EL PASO COUNTY PLANNING AND COMMUNITY DEVELOPMENT DEPARTMENT

SF-21-016

GRADING AND EROSION CONTROL PLAN CHECKLIST ROLLING HILLS RANCH FILING 3 SF 21-XXX

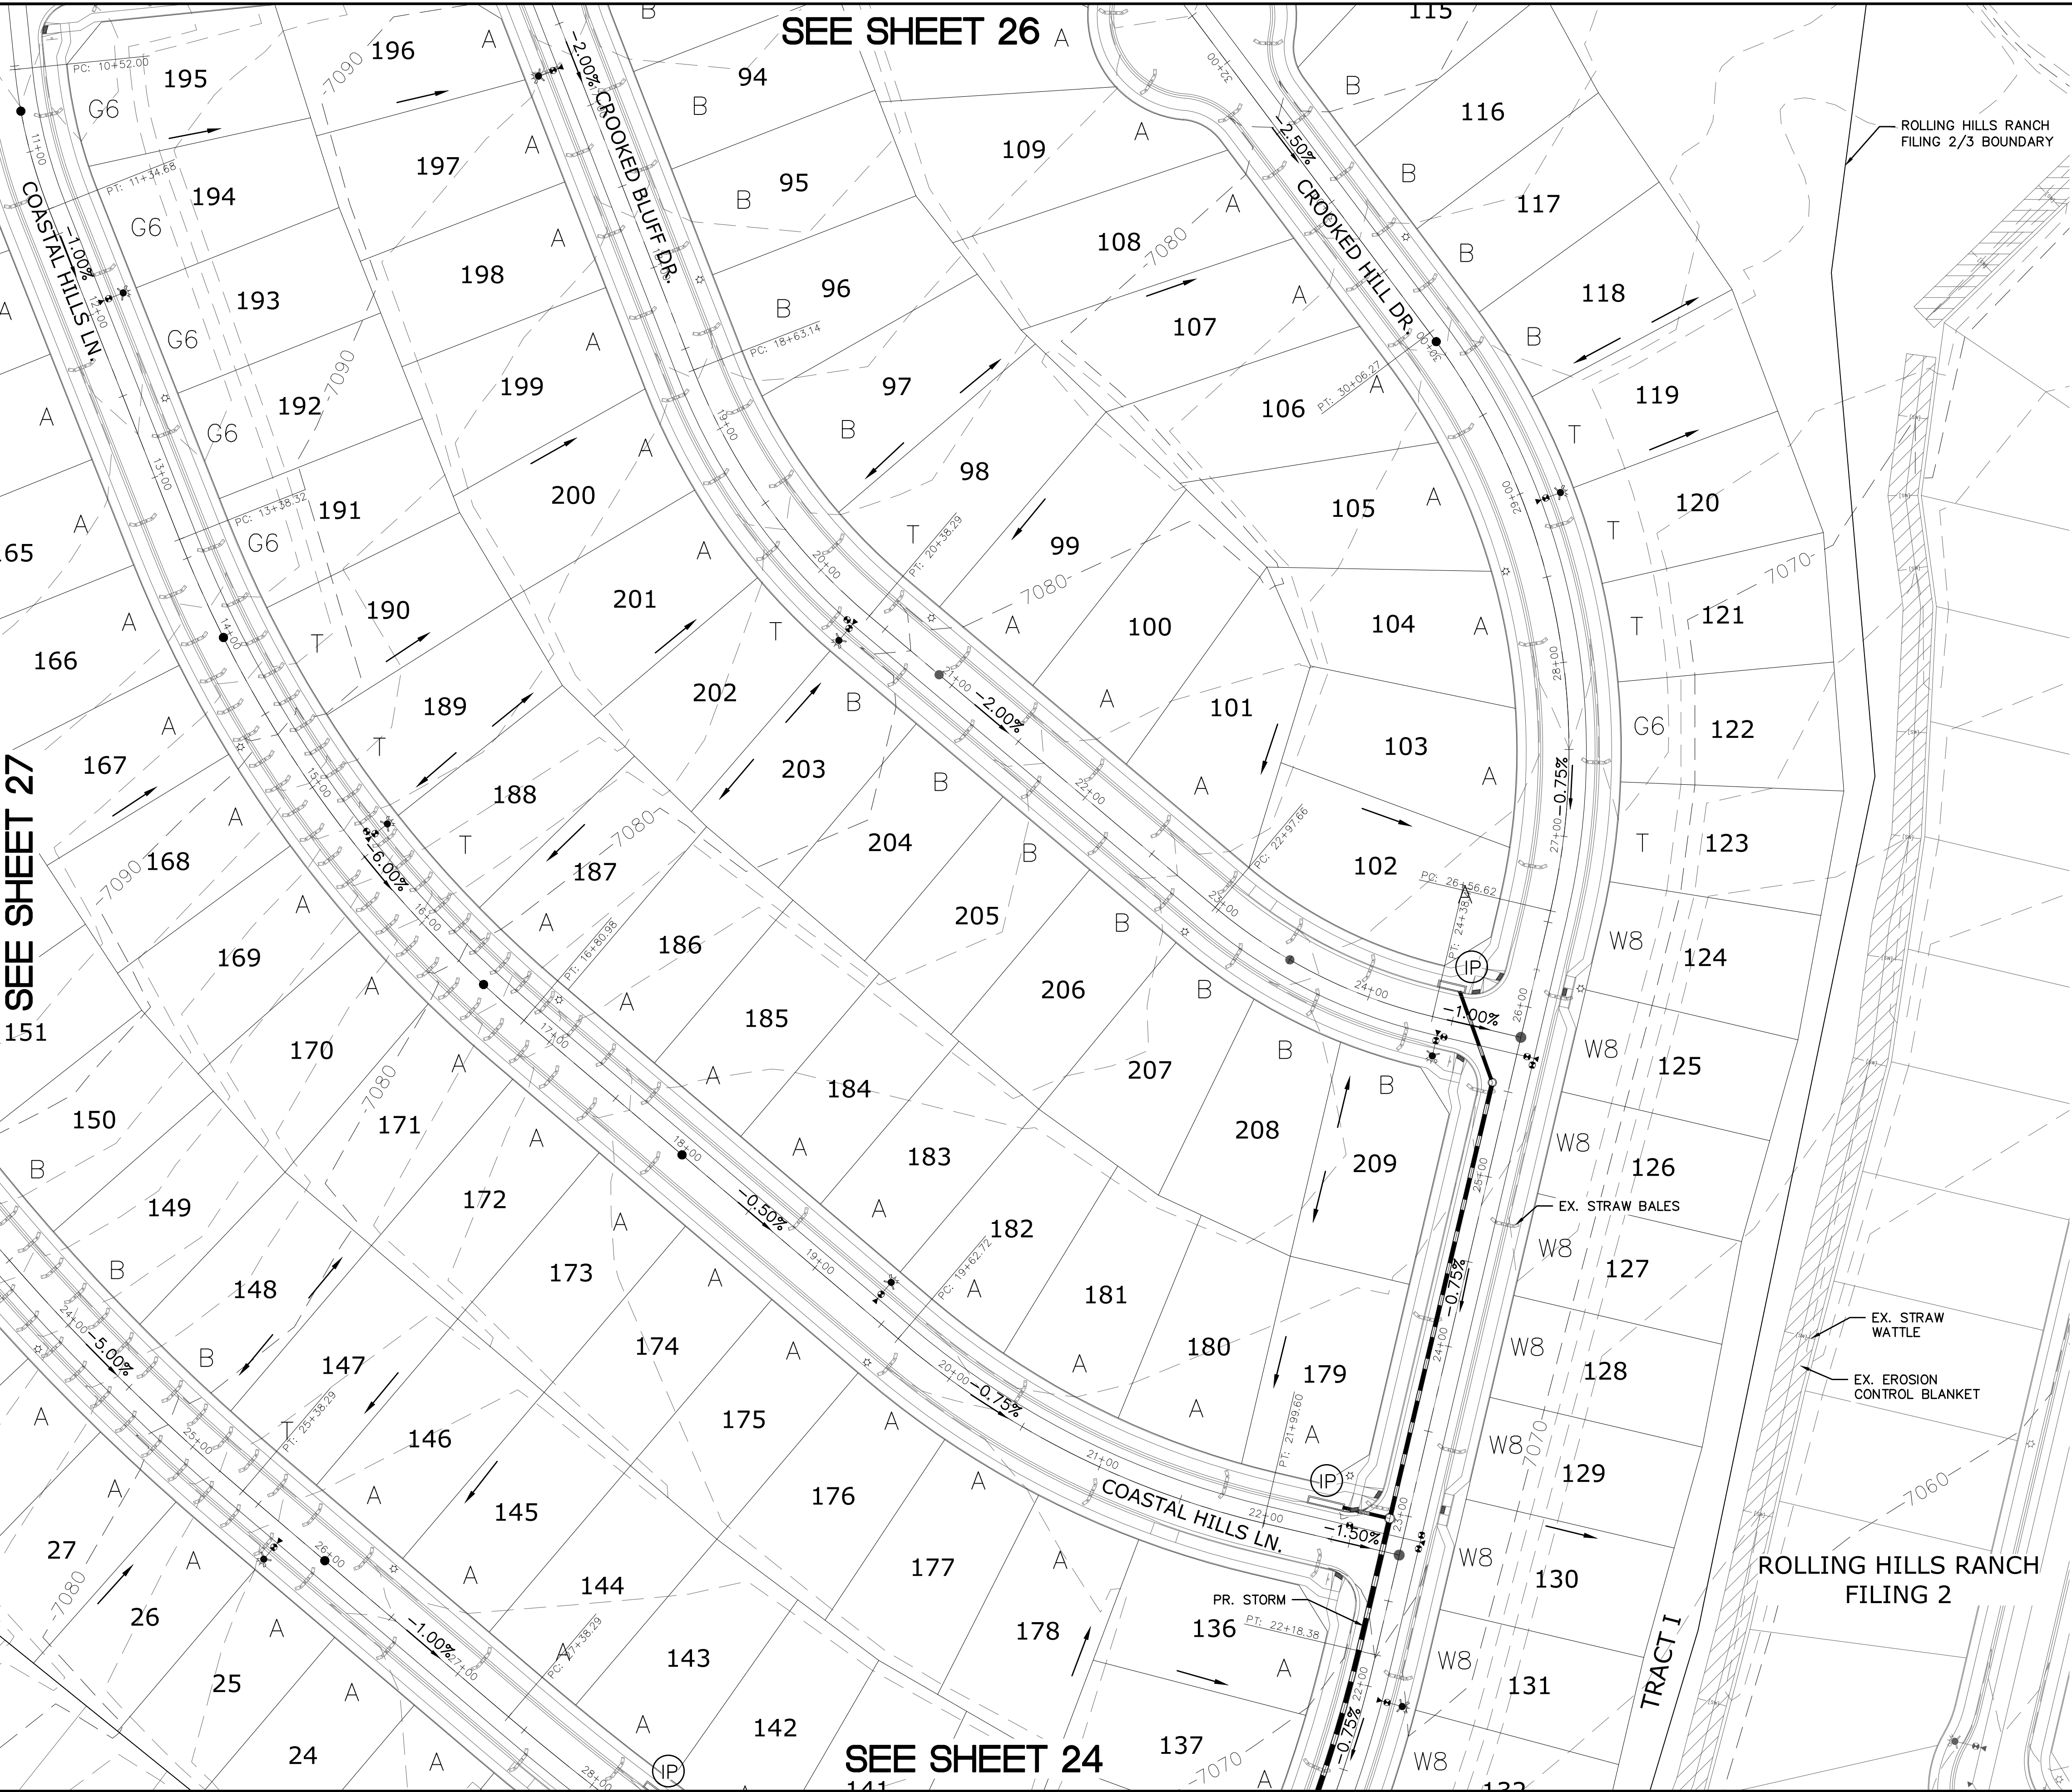
l	Existing and proposed contours 2 feet or less (except for hillside).	X	Y
m	Limits of disturbance delineating all anticipated areas of soil disturbance. See comment on Sheet 24	X	
n	Identify and protect areas outside of the construction site boundary with existing fencing, construction fencing or other methods as appropriate.	X	Y
o	Offsite grading clearly shown and called out.	n/a	N/A
p	Areas of cut and fill identified. Site grading already completed.	X	N/A
q	Conclusions from soils/geotechnical report and geologic hazards report incorporated in grading design (slopes, embankments, materials, mitigation, etc.)	X	
r	Proposed slopes steeper than 3:1 with top and toe of slope delineated. Erosion control blanketing or other protective covering required.	X	N/A
s	Stormwater flow direction arrows. Revise to N/A if true.	X	Y
t	Location of any dedicated asphalt / concrete batch plants.	X	N/A
u	Areas used for staging, storage of building materials, soils (stockpiles) or wastes. The use of construction office trailers requires PCD permitting.	X	Y
